**ENVIRONMENTAL ASSESSMENT EXHIBITION FOR MIXED USE BUILDING AT 6-16  
ATCHISON STREET, ST LEONARDS (MP09\_0187)**

Transport NSW has reviewed the Environmental Assessment (EA) report and appended Traffic and Parking Study (the 'Study'). The following comments are provided on specific aspects of the proposal and should be reflected in the final statement of commitments and potential future conditions of consent:

David Hartmann  
**A/ Senior Manager**  
**Centre for Transport Planning and Product Development**

www.ttmgroup.com.au

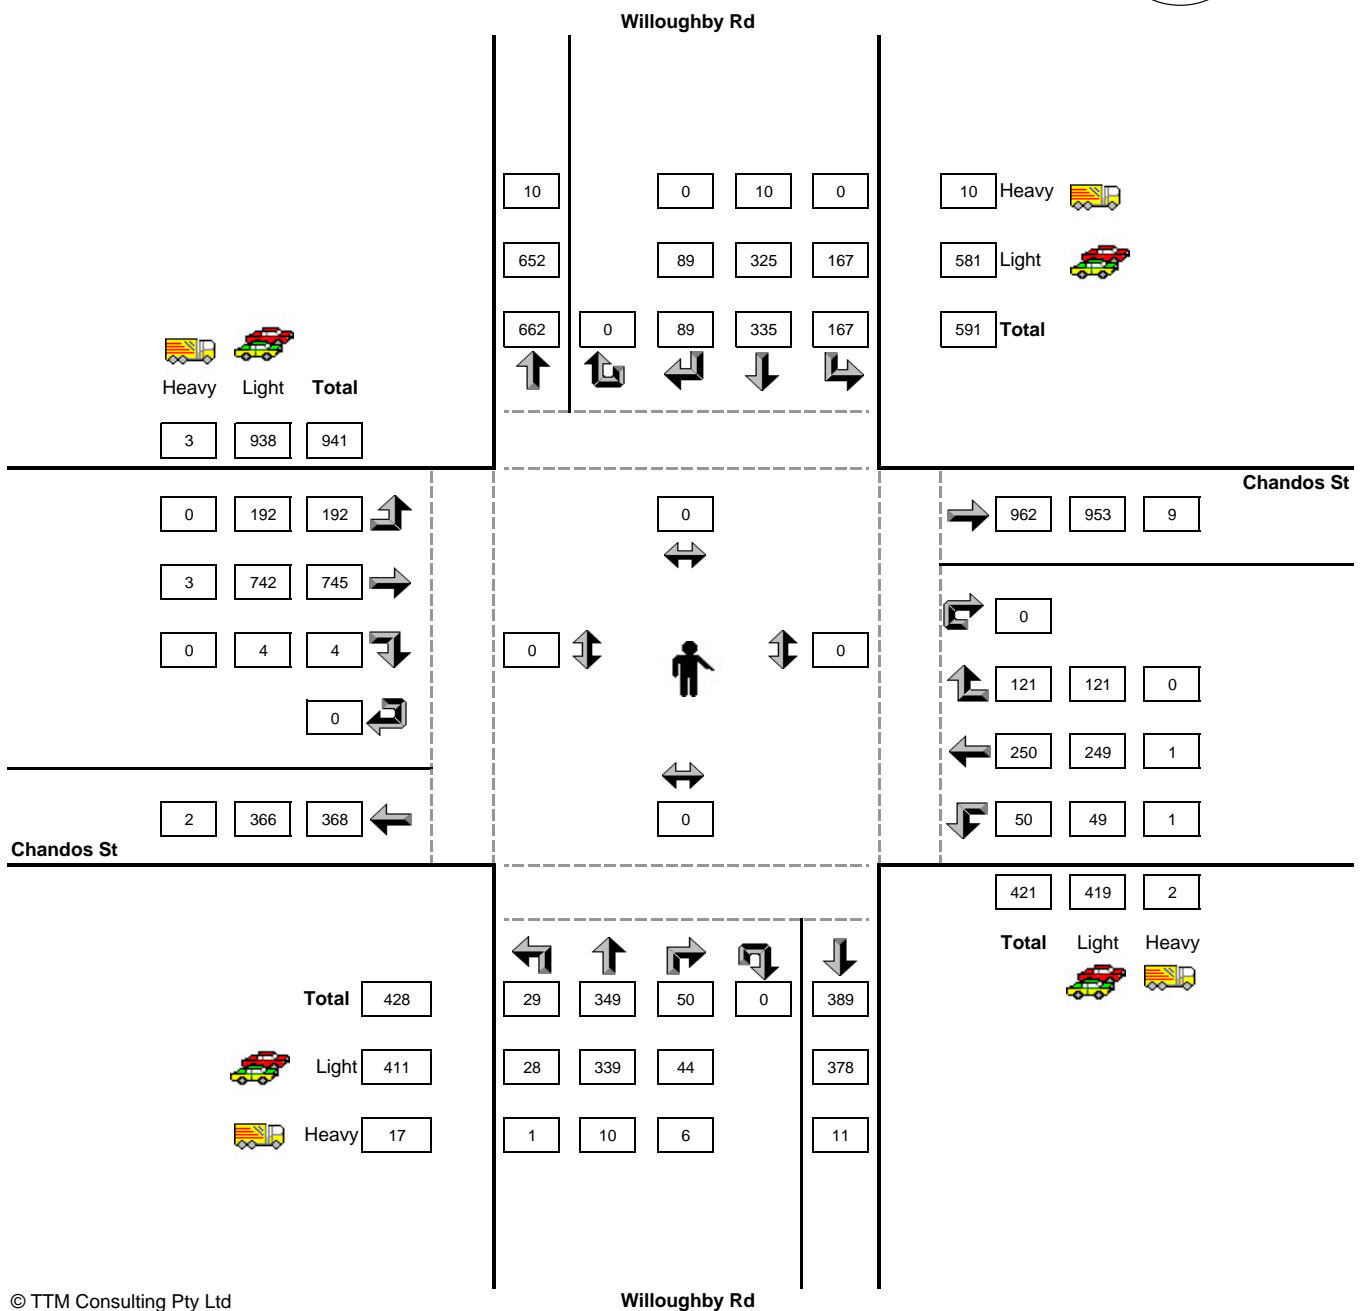
- Transport NSW queries the TTM Group pedestrian survey results that record no pedestrian activity within the survey period. Further consideration of pedestrian impacts and facilities is recommended.
